BRITISH HORSE SOCIETY – BEDS – COMMENTS ON DRAFT ASI ITINERARY (REP1-065)

At Deadline A, the BHS requested that the ExA visit Pertenhall BW26 and Bolnhurst & Keysoe BW37, identifying a number of points for the ExA to consider:

Client
BSSL Cambsbed 1 Ltd
Project
East Park Energy
Drawing Title

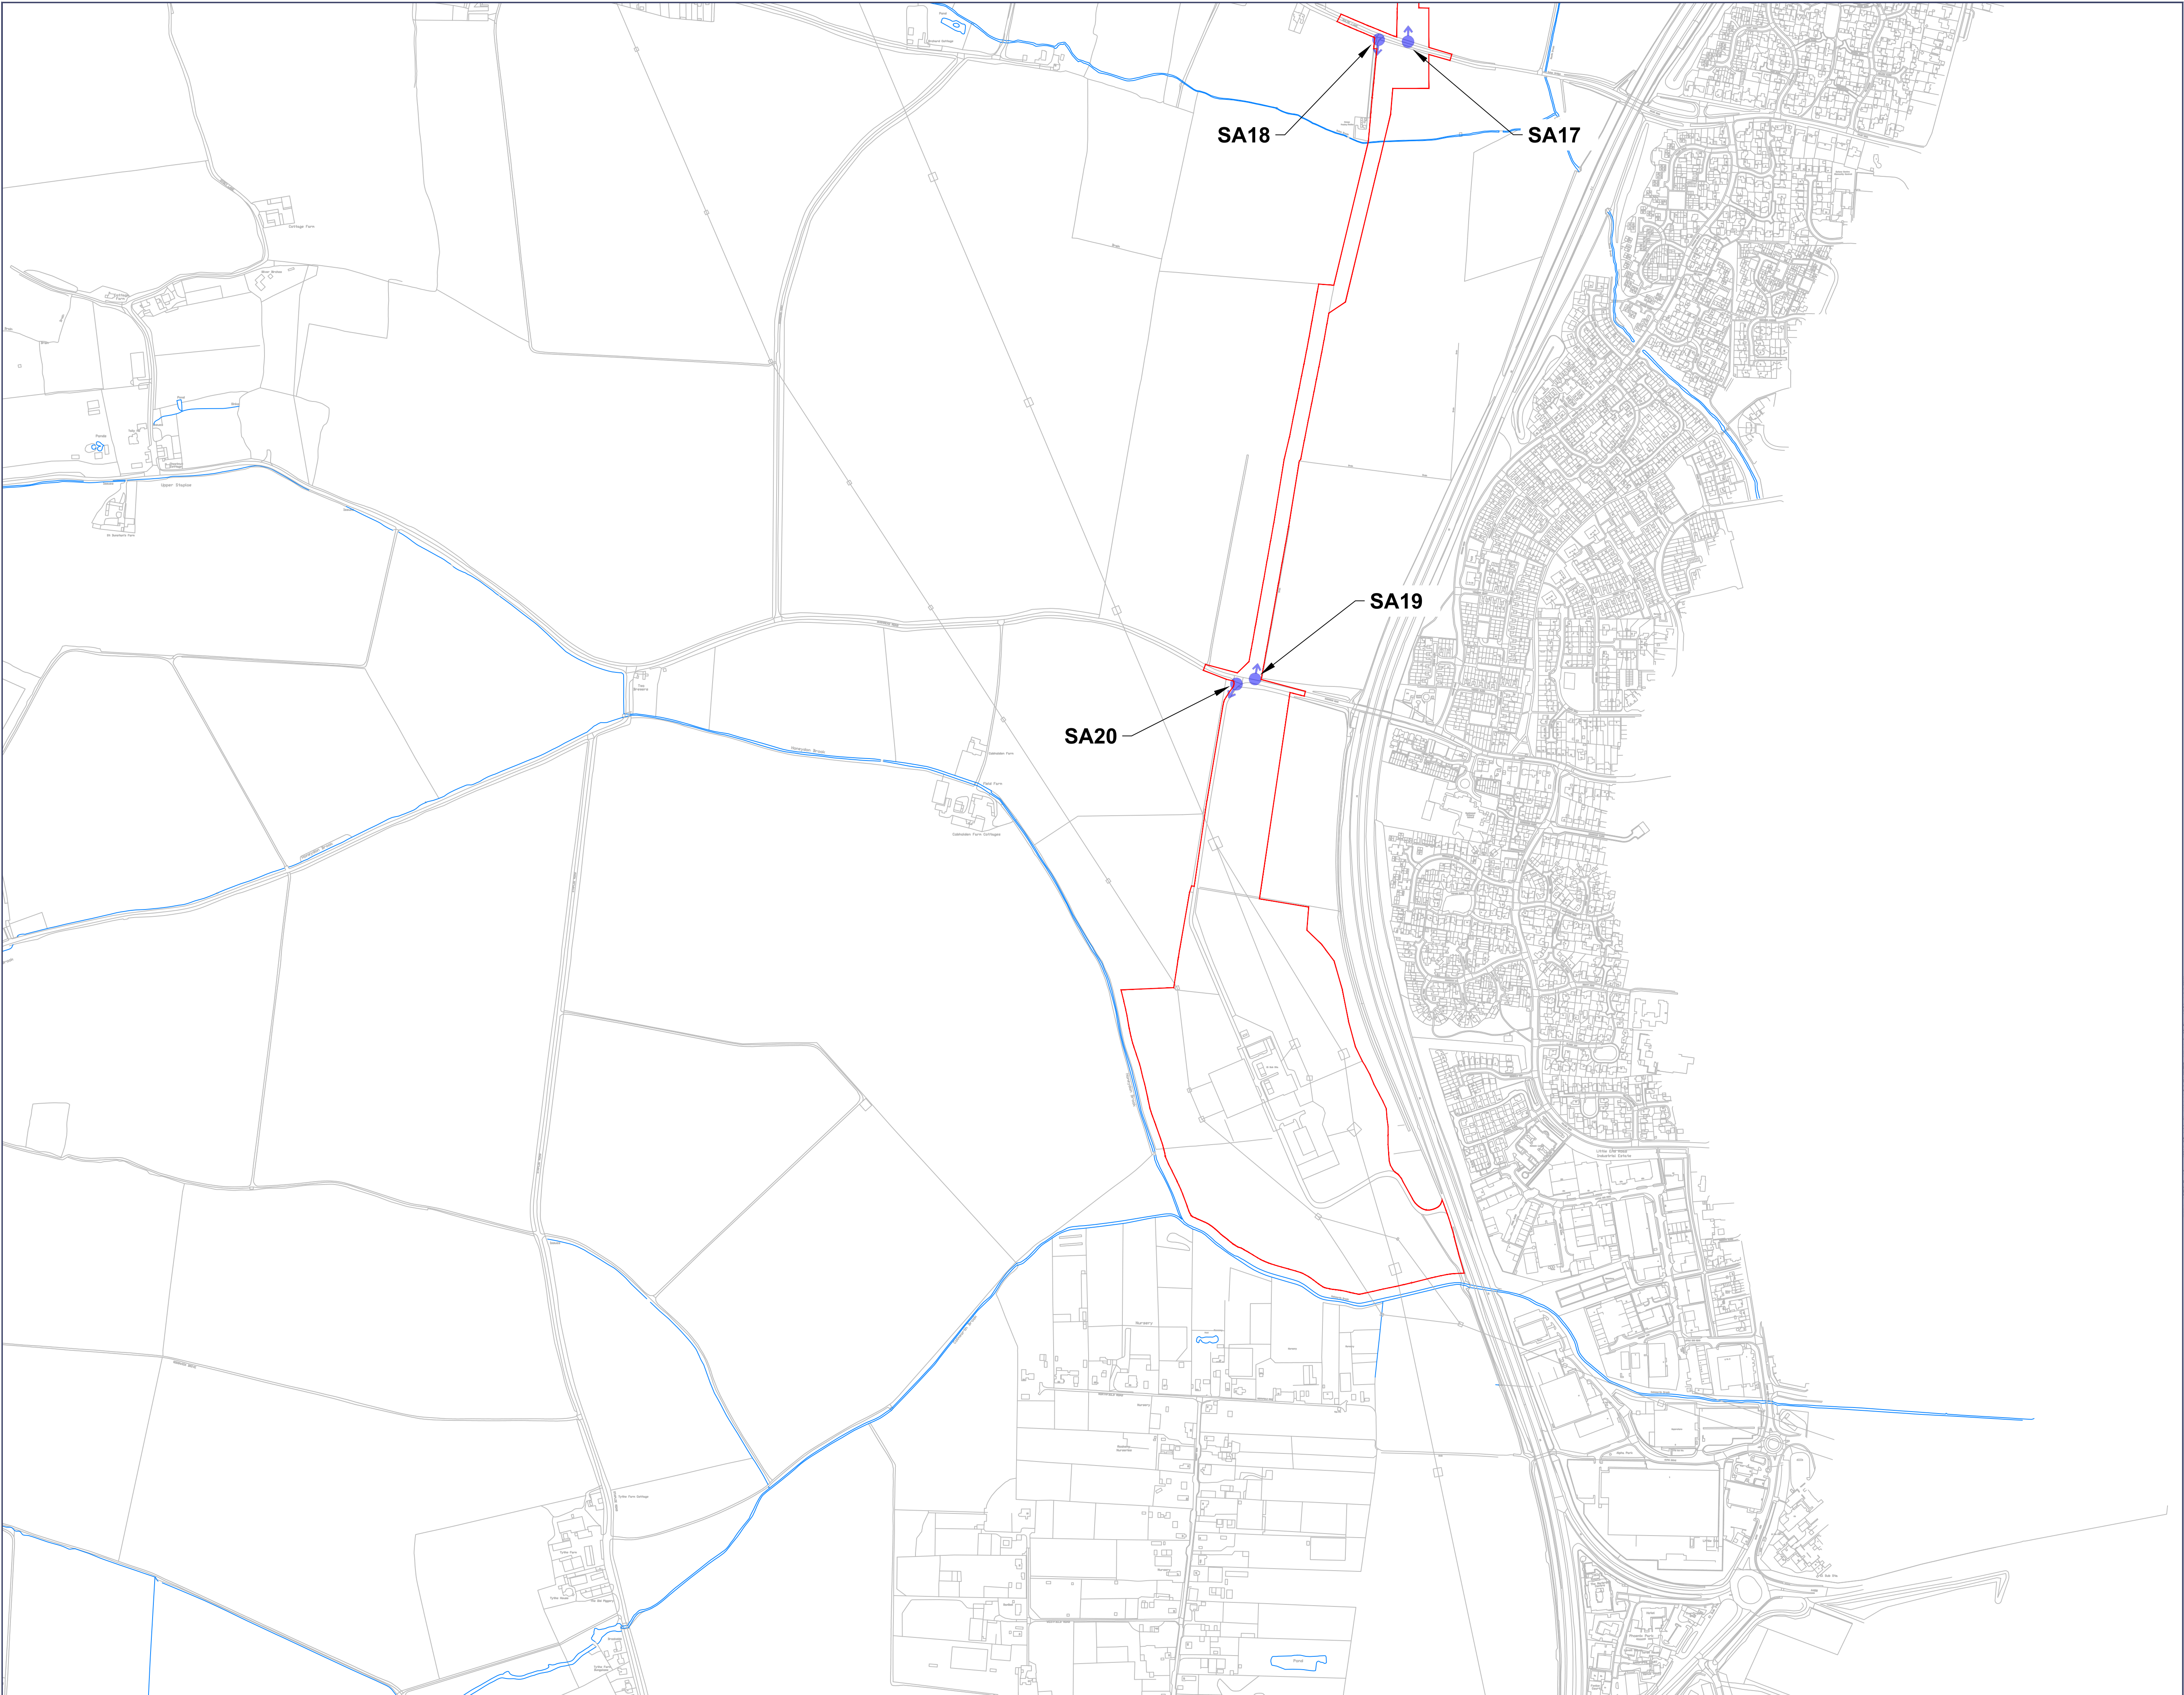
Between C and D, the Justification column of the itinerary refers to SA12 but not to the site access just before D, which curiously is not labelled on the Site Access plan (APP-124).

Likewise, the itinerary justification between D and E should refer to SA05. And the route should be extended to visit SA03.

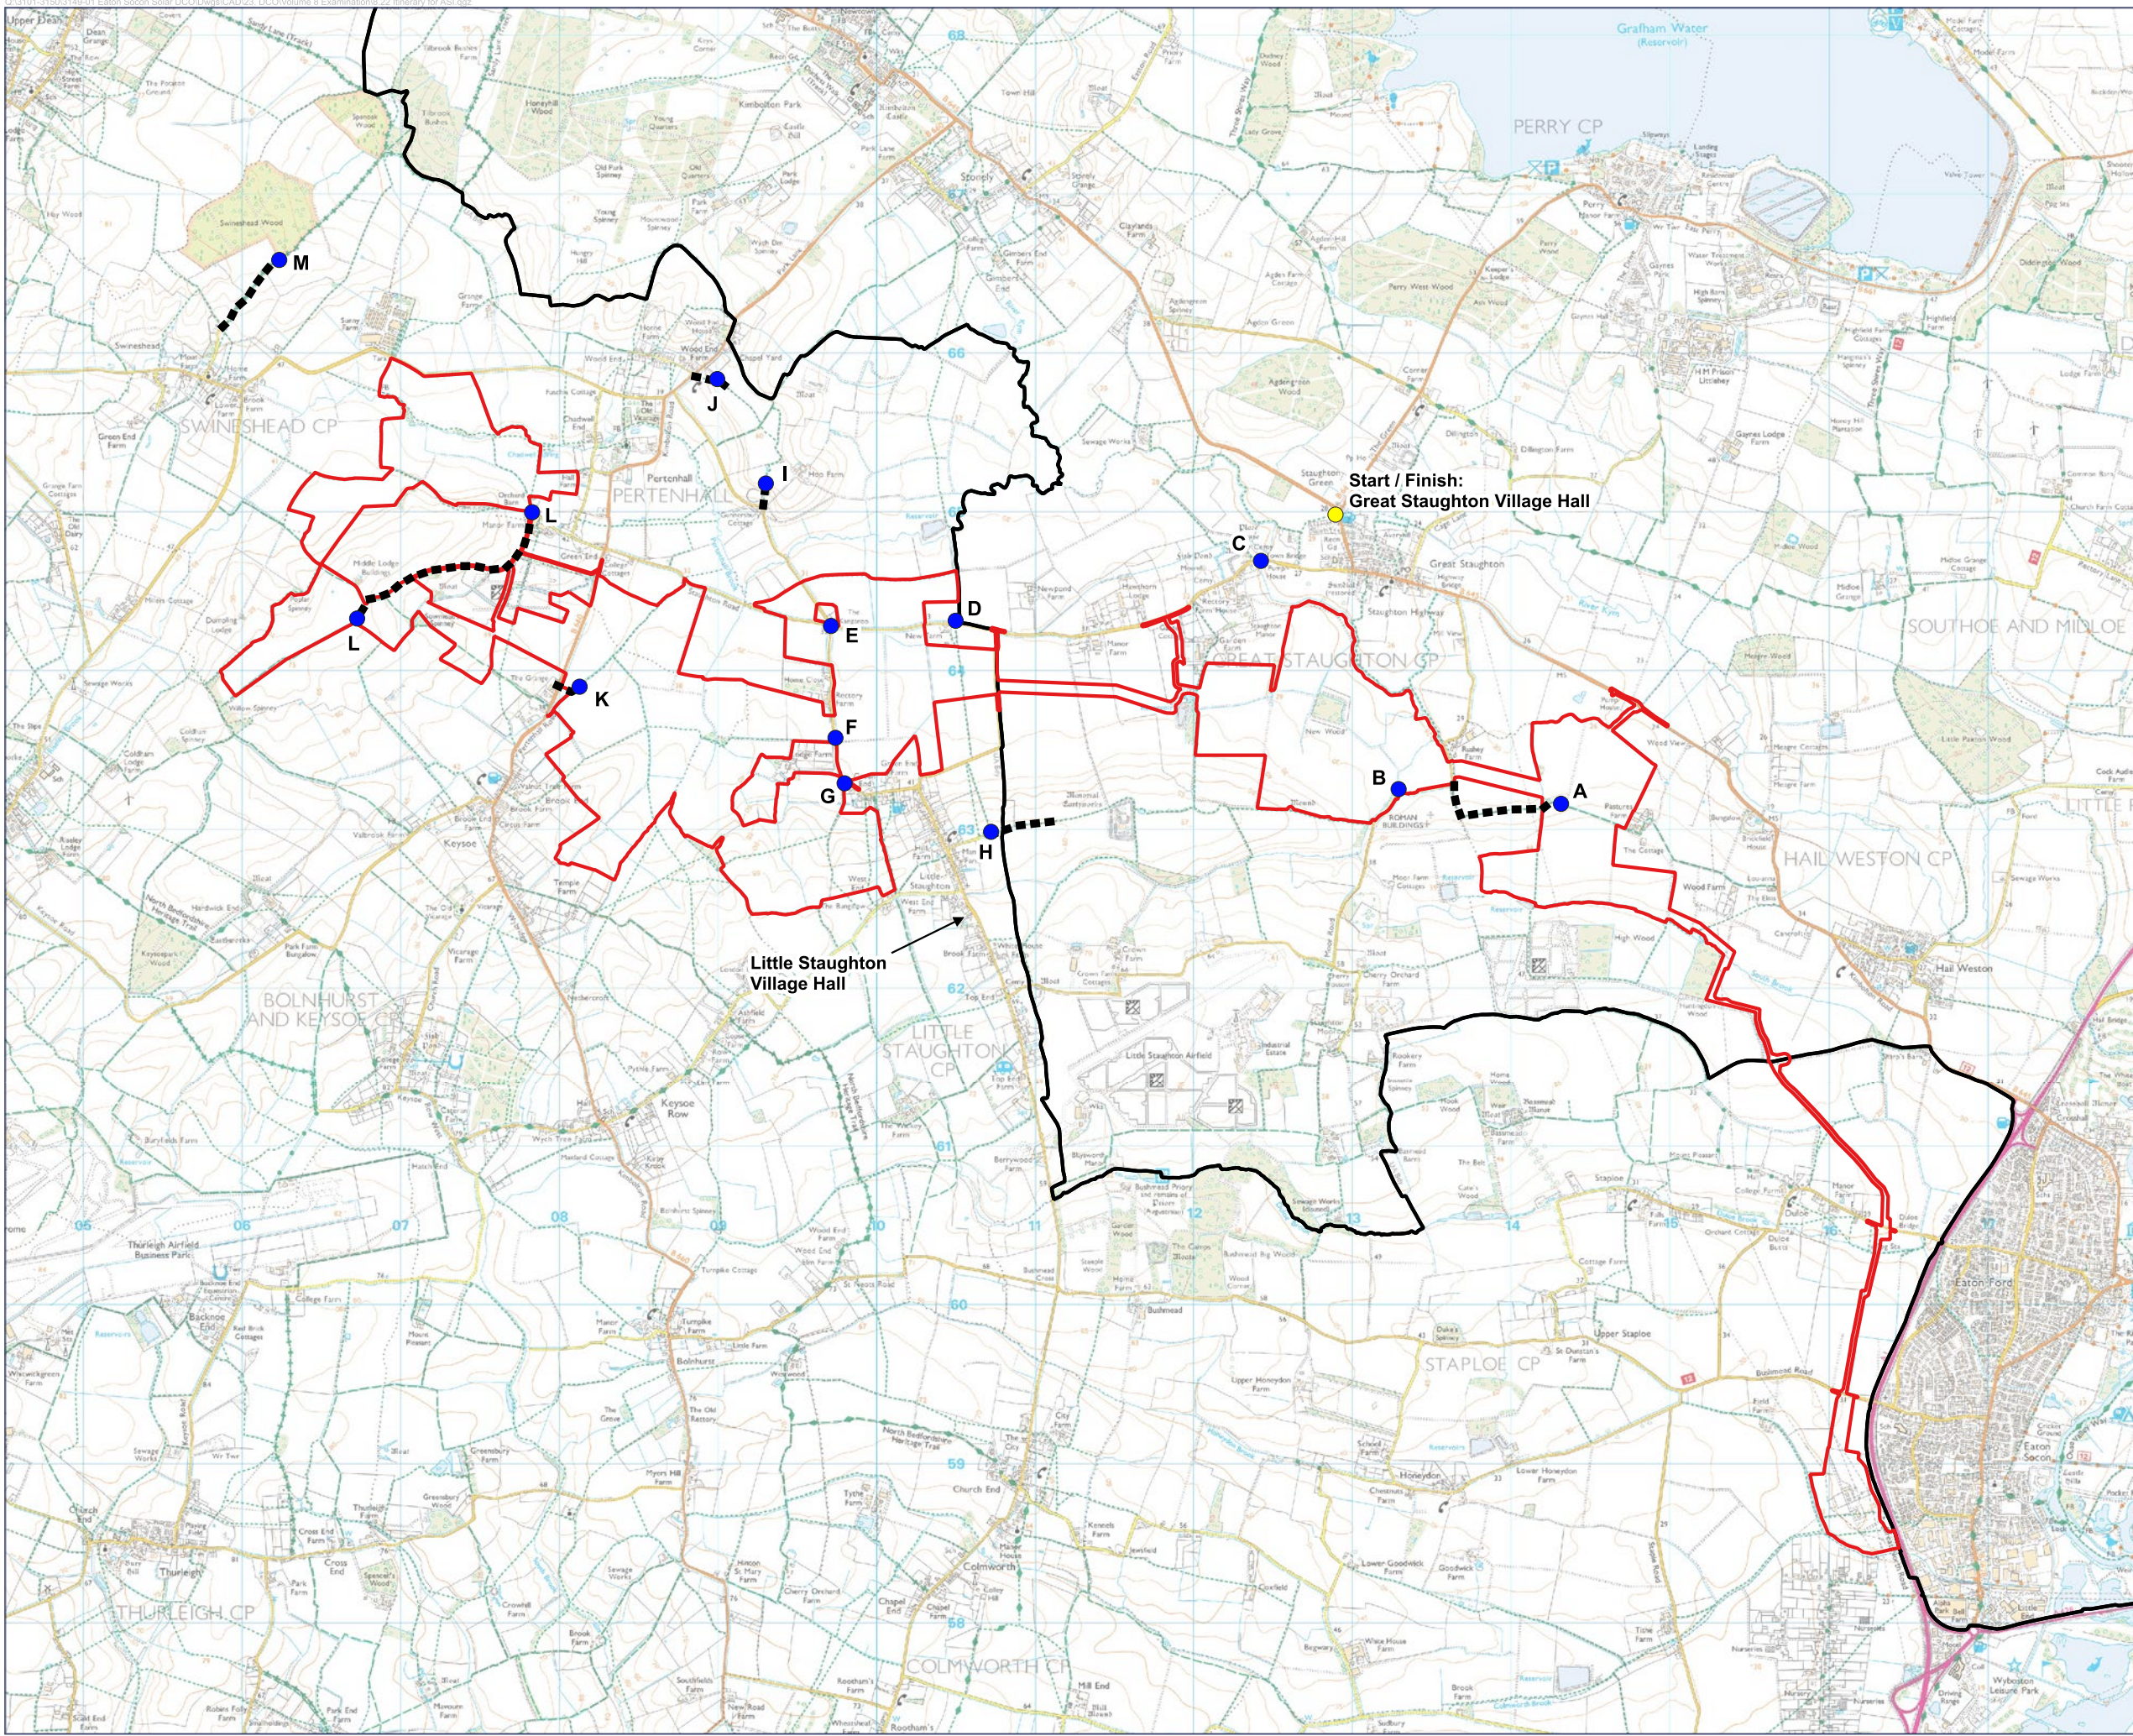
The current draft itinerary should address the first, and possibly the second, but only partially addresses the third and ignores the last.

Further, it is on foot which may well be appropriate in looking at the first two points, but it should be possible to complete the rest of the visit in a vehicle, with stops at key points.

The omission of the views on the further part of BW37 is of particular concern to us – these are the most valued views on the BW and the ExA will apparently not see them. Indeed, it appears that he will stop at just the point that the views to the north become most impressive – the topography means that these impressive views are not visible when on foot until about that turning point.

I appreciate that time will be limited so I would suggest that the ASI visits L to L1 on foot and then takes a vehicle up to L2, stopping at key points (the proposed diversion crossing, the BW40 crossing and viewpoints 9, 12 and 14).

Although the justification in the itinerary does note that the section between C and D will be used by construction traffic, there are other sections of the route where this is also true, but this is not noted. The omitted references include most of the routes identified as being used by equestrians. On the extract below, the green lines indicate the sections of route that the Society has expressed concerns about.

The itinerary justification should also note that that section from E-F-G will be used by construction traffic.
